Proposed Liquid Waste Treatment Plant  
SSD 8304  
**Response to Submissions Report**

DGL Group Limited  
(Formerly Hydromet Corporation Pty Limited)  
201 Five Islands Road Unanderra, New South Wales  
Planning Plus (NSW) Pty Ltd  
Project 20105– December 2021

Proposed Liquid Waste Treatment Plant  
201 Five Islands Road Unanderra, New South  
Wales.

Figure 2: Project setting and receptor locations

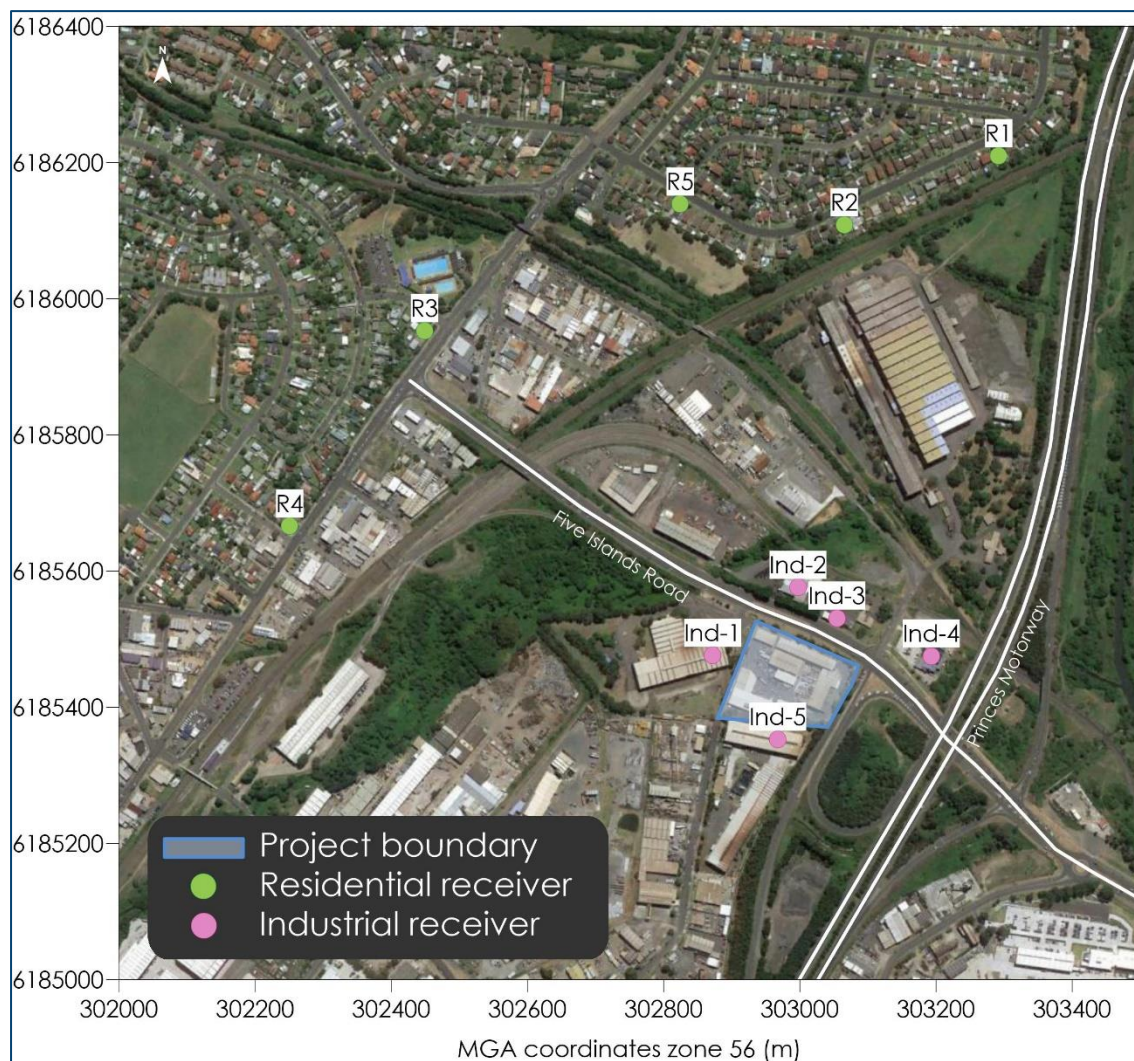
<ul style="list-style-type: none"> <li>The table of sensitive receivers does not appear to include the Aquatic Centre. Please confirm if this receiver has been assessed. Noting that the current EPL includes a noise limit of 45dBA at the Aquatic Centre.</li> </ul>	<p>Noted. Addressed in Response to Submissions Report by Todoroski Air Sciences in <a href="#">Attachment D</a>.</p> <p>The Aquatic Centre at 1 Marley Place is identified as Receiver Ind-4 in the Noise Impact Assessment.</p>
<p><b>Soil and Water</b></p> <ul style="list-style-type: none"> <li>Update the flood assessment to address Council comments. Including amending flood controls based on the most up-to-date flood level information, being Council's adopted Allans Creek Flood Study dated 2019, and the relevant controls in Appendix C of Chapter E13 Floodplain Management of the Wollongong Development Control Plan (DCP) 2009.</li> </ul>	<p>The Flood Risk Management Report has been updated in consultation with Wollongong City Council and the requirements of the latest Allans Creek Flood Study dated 2019. Council Engineers have viewed the updated Report and informally endorsed it but await formal referral from DPIE to give formal comments and draft conditions of consent.</p> <p>The updated Report is located in <a href="#">Attachment F</a>.</p>

Figure 3: Predicted annual average Pb concentrations ($\mu\text{g}/\text{m}^3$)

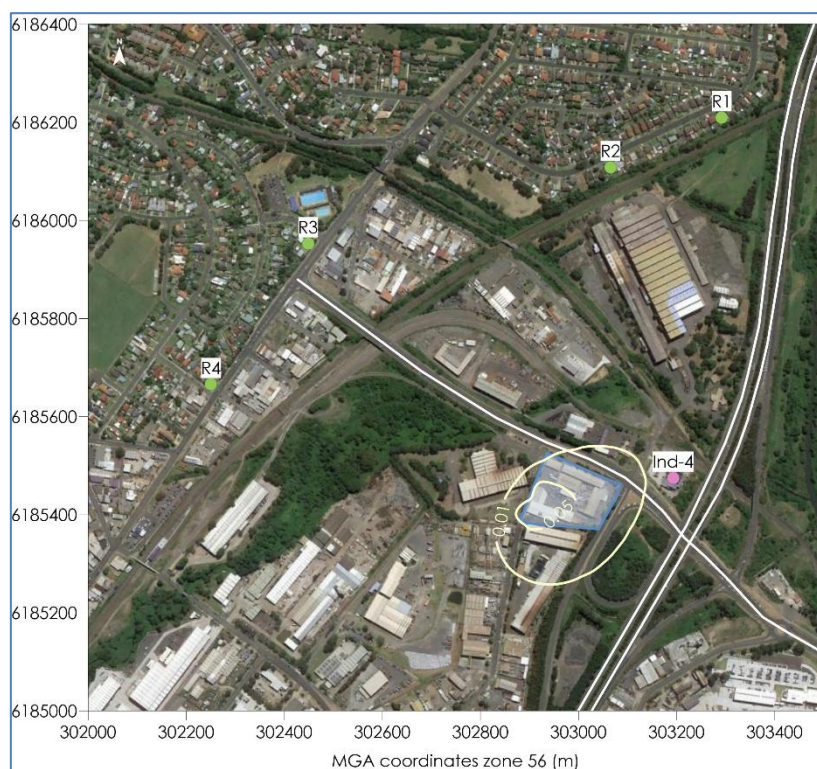
Furthermore, it is noted that Table 7-3 and associated Figure 7-9, lists the impact assessment criterion for lead as 0.5 µg/m<sup>3</sup> at 1-hour average, rather than annual. Whilst it is likely a typographical error, and it is recognised that a 1-hour criterion presents a more conservative approach, for complete transparency it should be corrected in the revised assessment.

**2) Address identified inconsistencies between the AQIA and Approved Methods for the Modelling and Assessment of Air Pollutants in NSW in regards to correct averaging periods for assessing impacts of lead emissions.**

Noted and addressed in Response to Submissions Report by Todoroski Air Sciences in [Attachment D](#).
